### **McCune Ranch, SP-18-006**

**Please accept the following revised comments from El Paso County Public Health (ECPH) regarding the proposed subdivision referenced above:**

**Mike McCarthy, R.E.H.S.**  
**El Paso County Public Health**  
[mikemccarthy@elpasoco.com](mailto:mikemccarthy@elpasoco.com)  
**719-575-8602**  
**18Nov2018**

## SITE PLAN

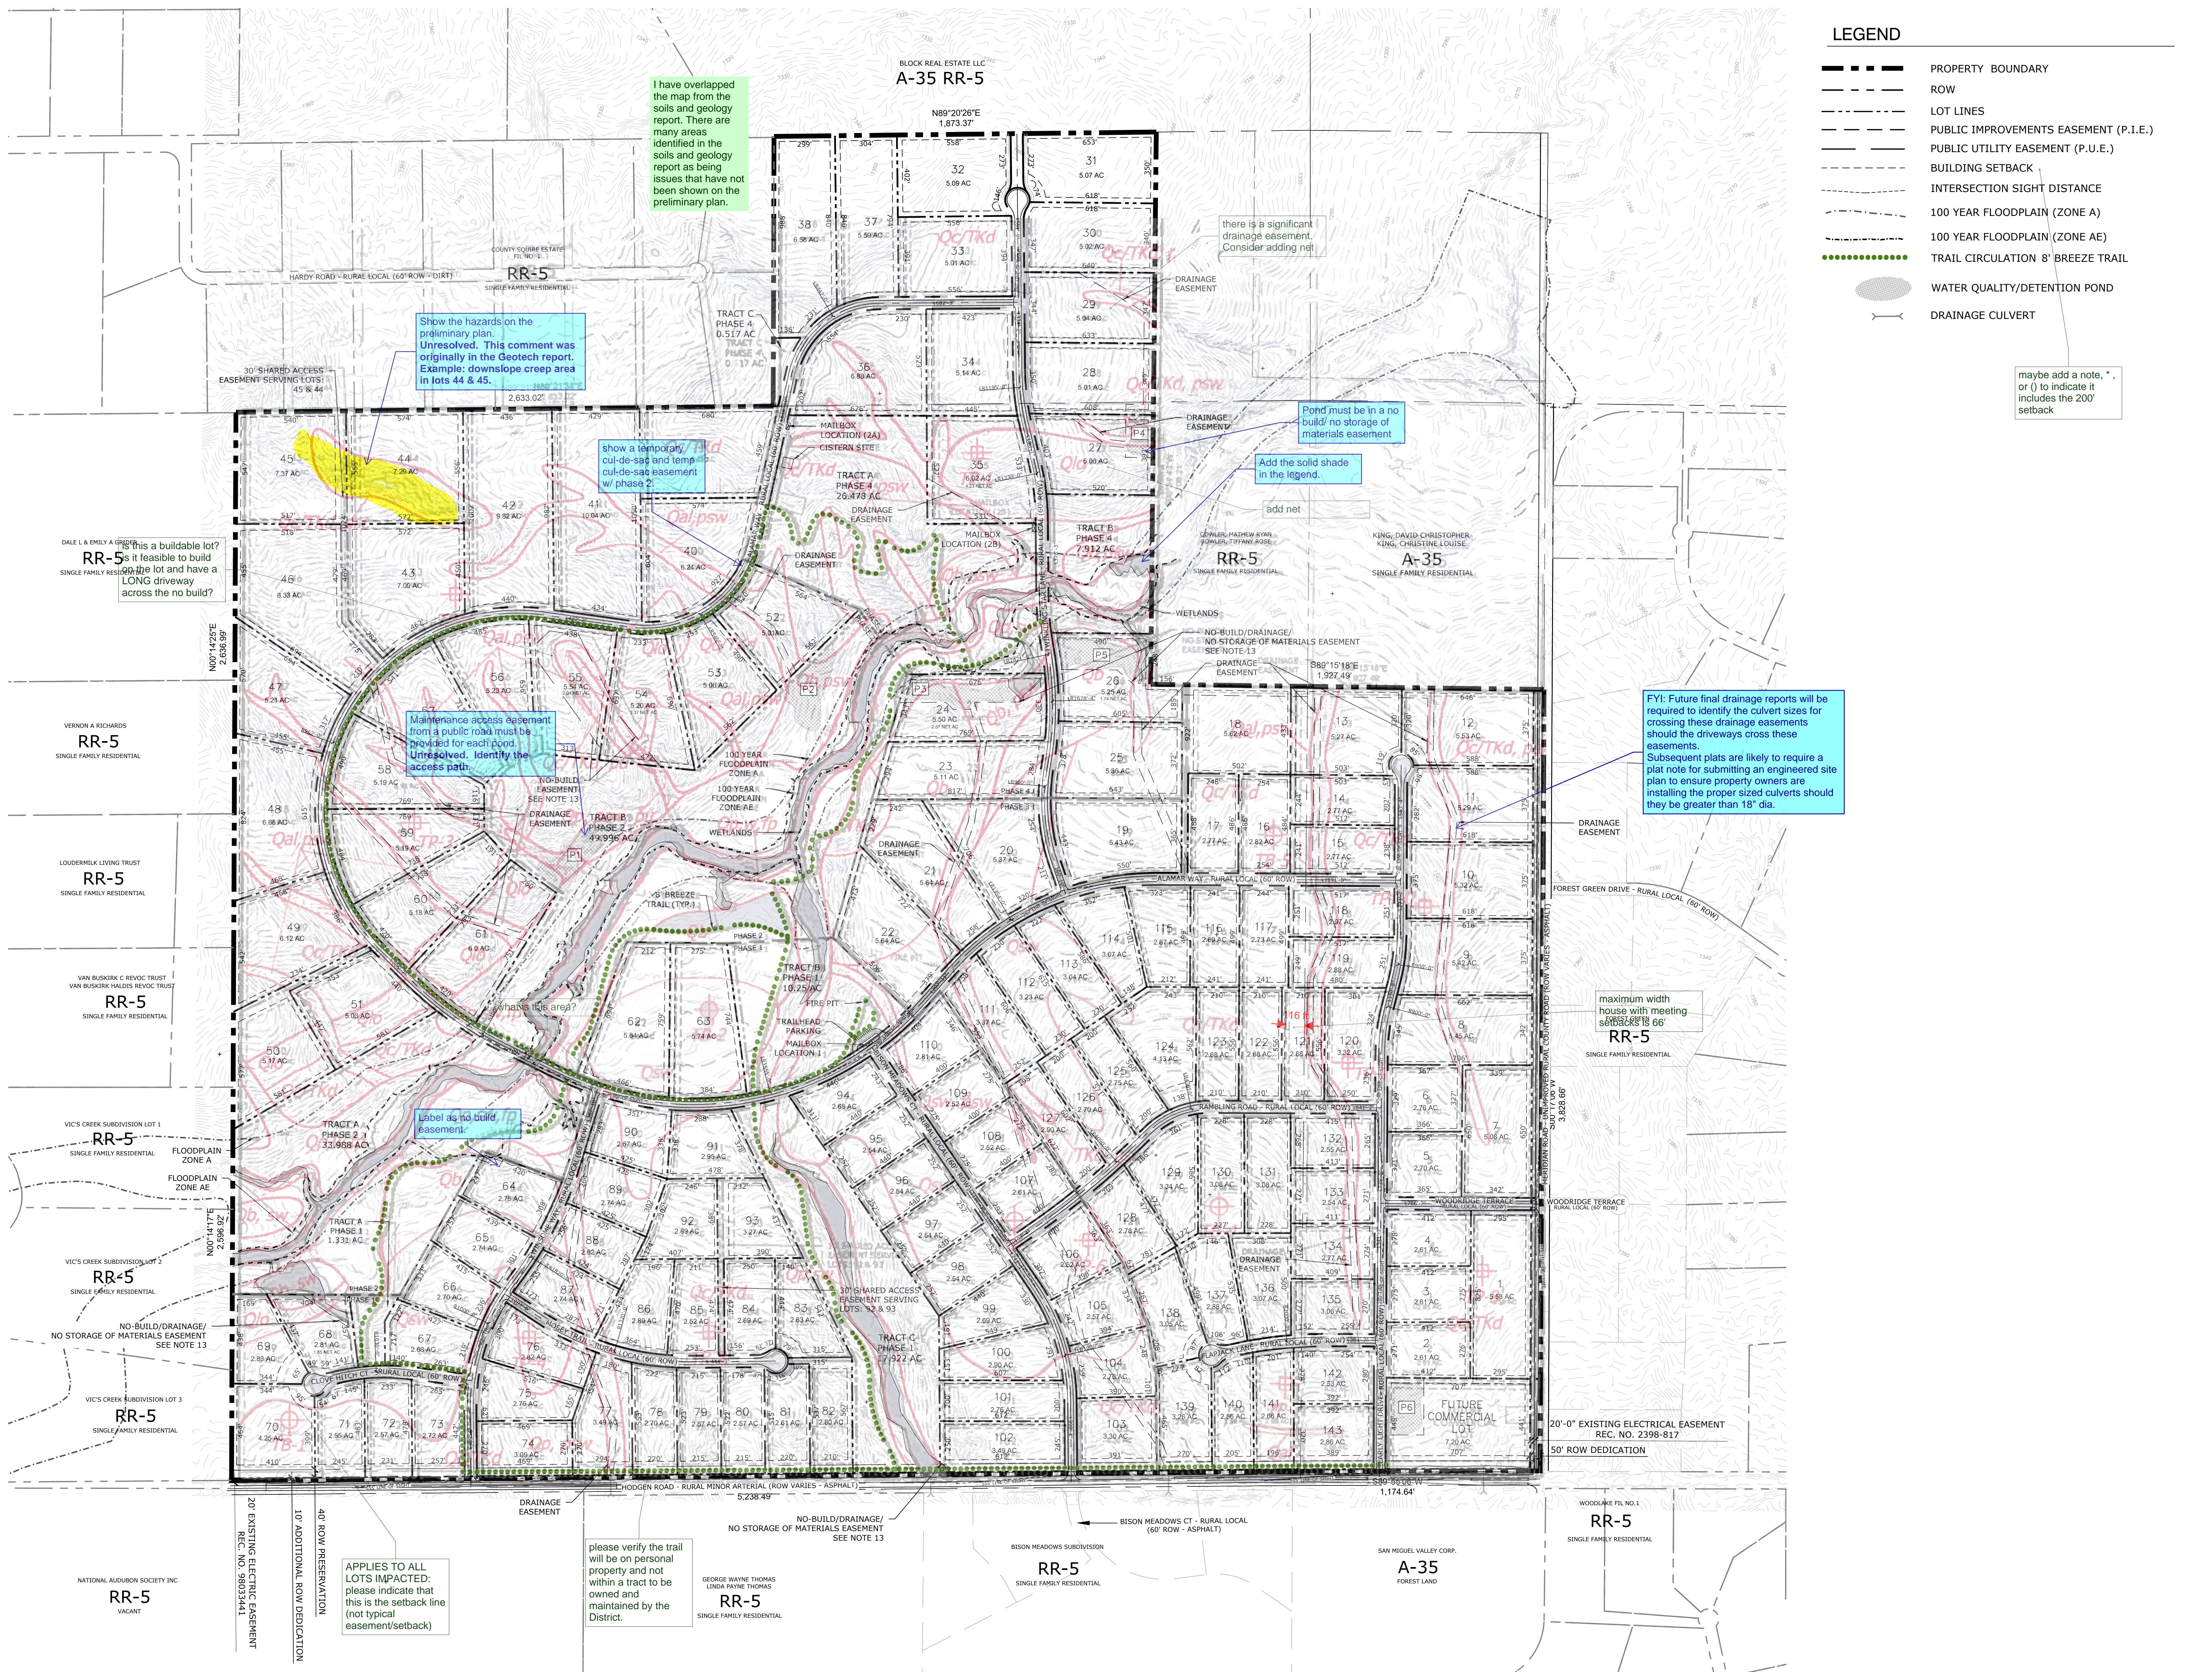
- Lots 5 - 11
  - Lot 21
  - Lots 23 - 24
  - Lot 41
  - Lot 44 for an identified downslope creep area in mid-lot
  - Lot 49
  - Lot 52
  - Lot 55 for an unstable slope area in mid-lot

SEPTIC SUITABILITY MAP
WINSOME SUBDIVISION
17480 MERIDIAN ROAD NORTH
EL PASO COUNTY, CO.
FOR: PROTERRA PROPERTIES, LLC

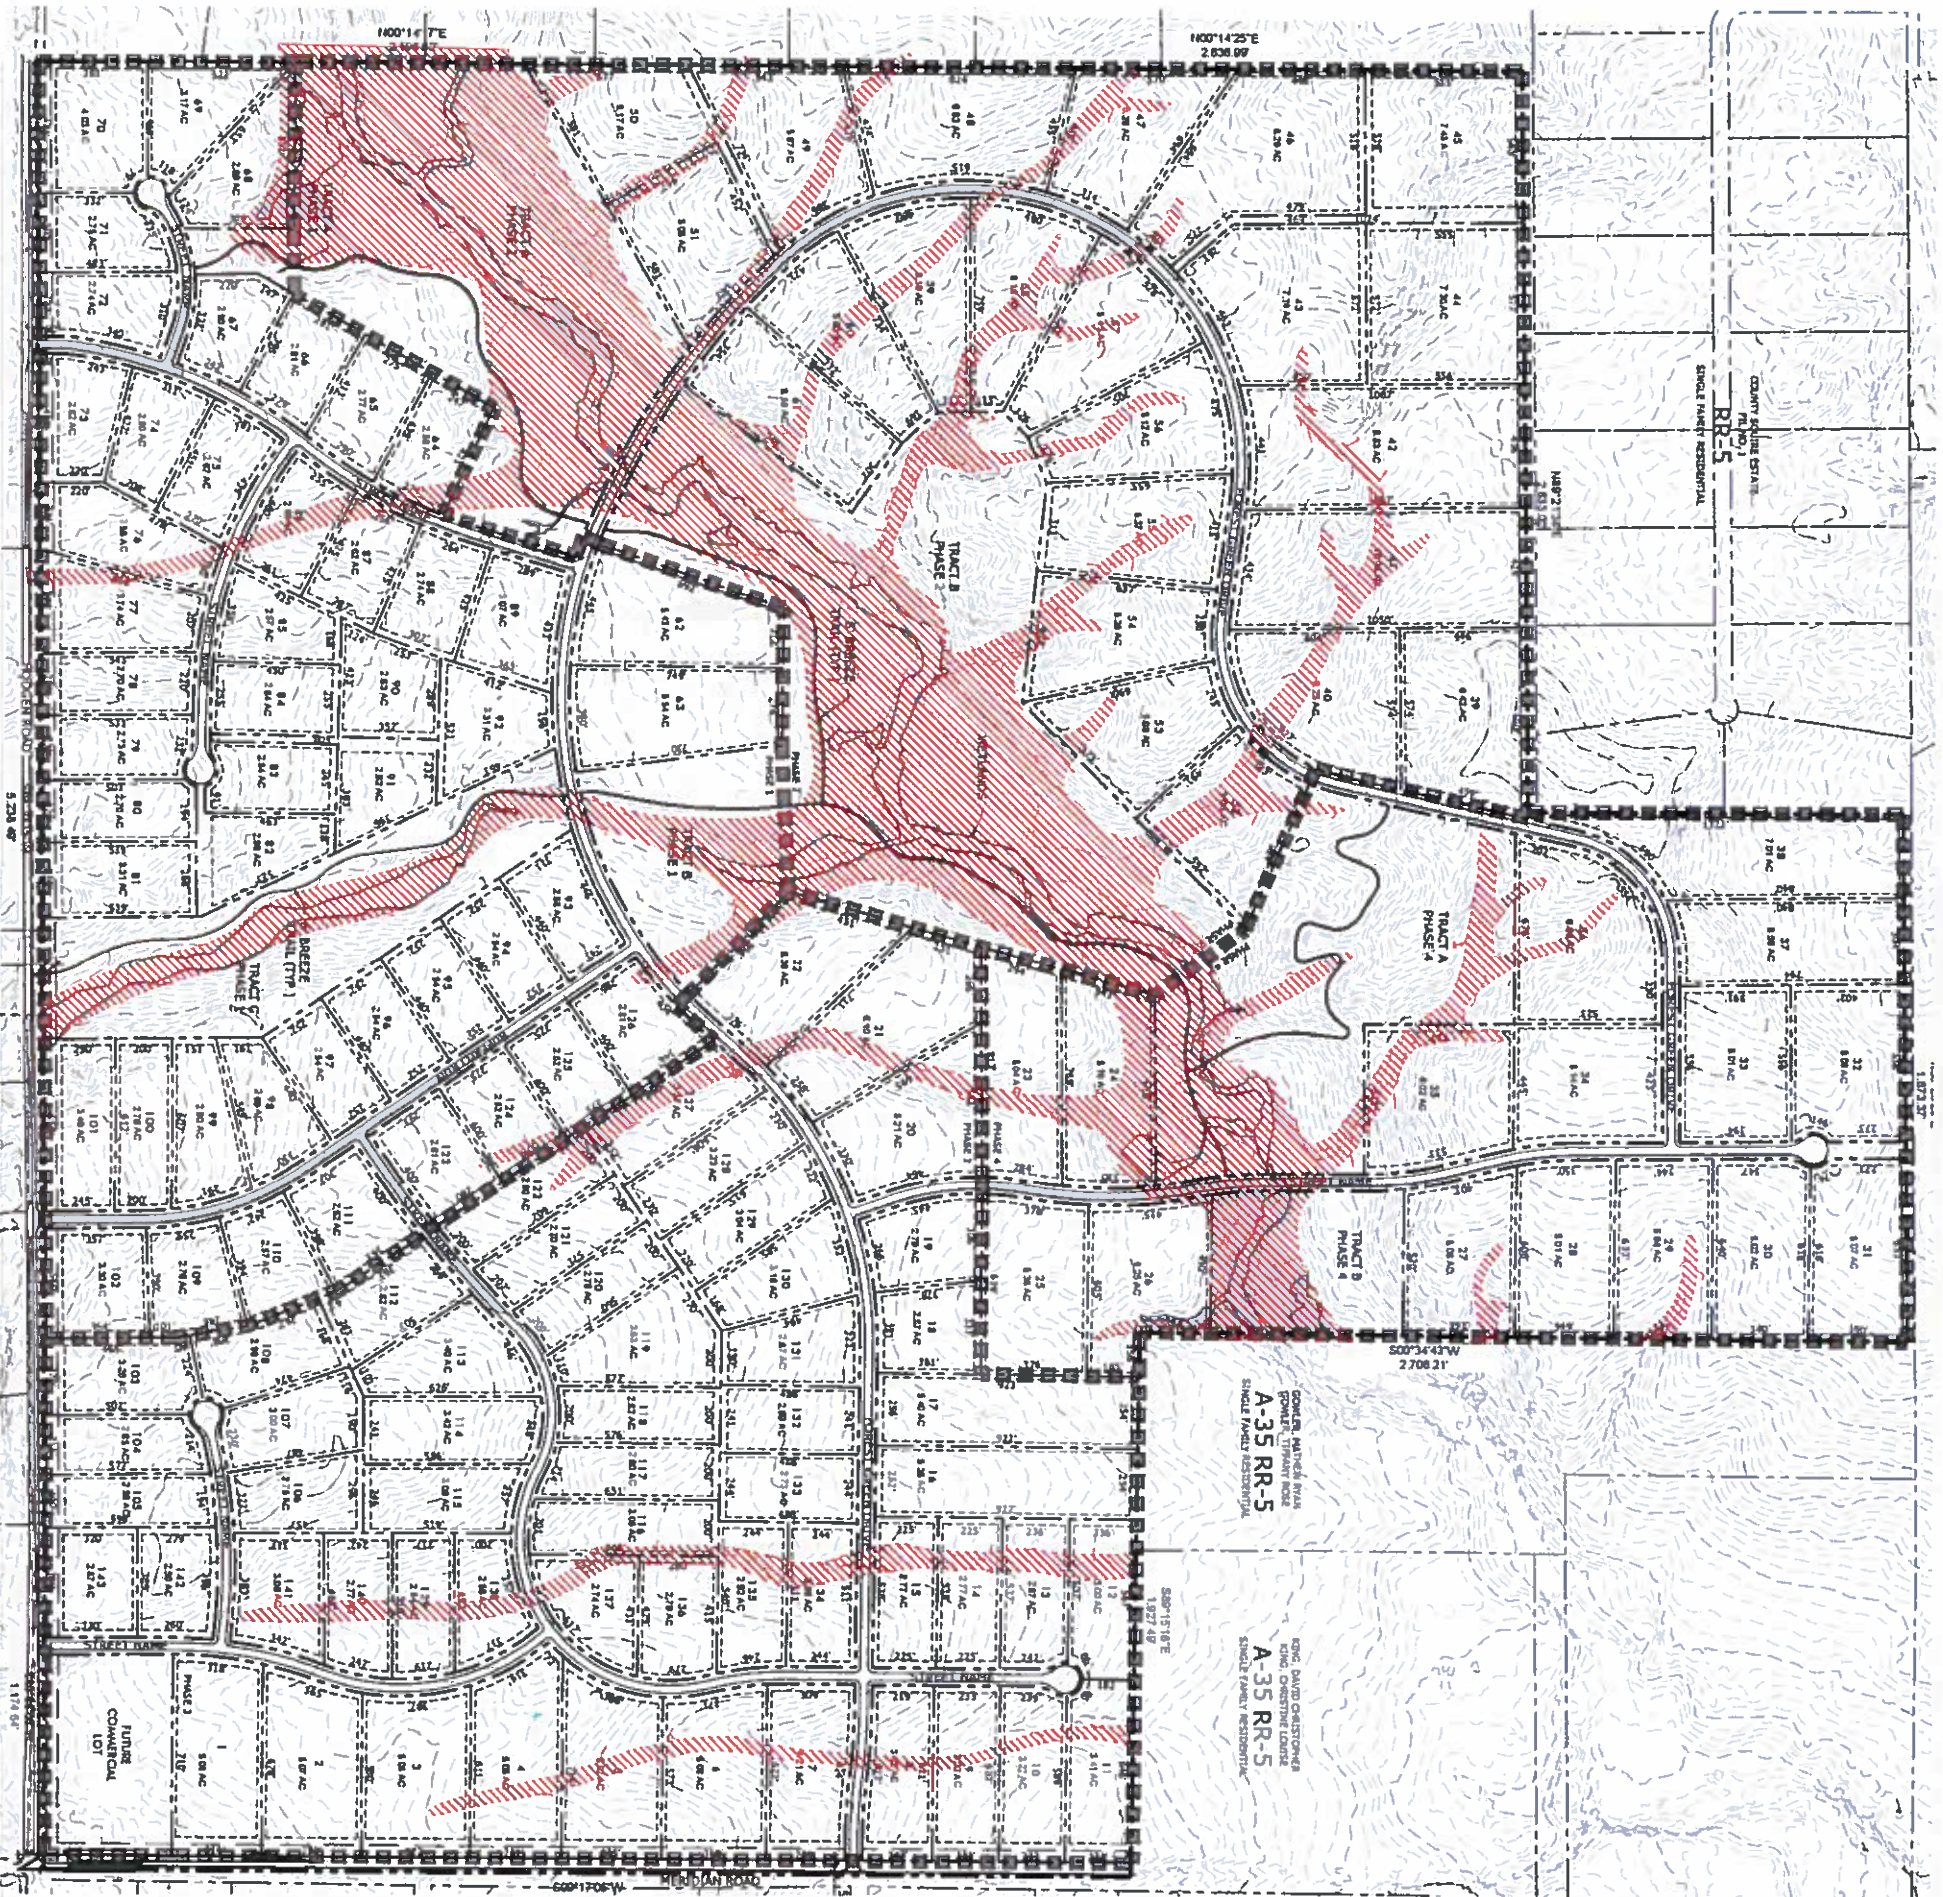
- Note: The 10 soil test pits within the report did indicate that ground water was not encountered; however, the report did show the majority of the soil in the area is not suitable for conventional onsite wastewater treatment systems and will require professional engineers design. ECPH encourages the remaining 19 soil tests be conducted in a few of the lot areas listed below. The most common reason for concern are the lots identified on Figure 9 of the Entech Engineering, Inc., Preliminary Soil, Geology, Geologic Hazard and Wastewater Study dated 02Oct2018, for McCune Ranch showing "areas that are not suitable for onsite wastewater treatment systems".

- The identified unsuitable areas appear to bisect the following lots, and depending on whether these identified areas can be crossed by the access driveways, may place a potential house site and OWTS in an area on the lot too small for locating the house, OWTS, and well, but still have the ability to meet all the minimum internal and external lot OWTS installation setbacks. The lots listed are based upon review of the Figure 9 map only, and may not have created as significant of an access issue to the back area of the lot as they appear to have created.

Regardless, at this time there appear to be potential OWTS installation issues for the following lots:

- Lots 57 – 61
  - Lot 86
  - Lot \*127 (not Lot 128 as noted in the report narrative)
  - Lots 134 - 135
  - Lots 138 - 141
- 
- Radon resistant construction building techniques/practices are encouraged to be used in this area. The EPA has determined that Colorado, and the El Paso County area, have potentially higher radon levels than other areas of the country.
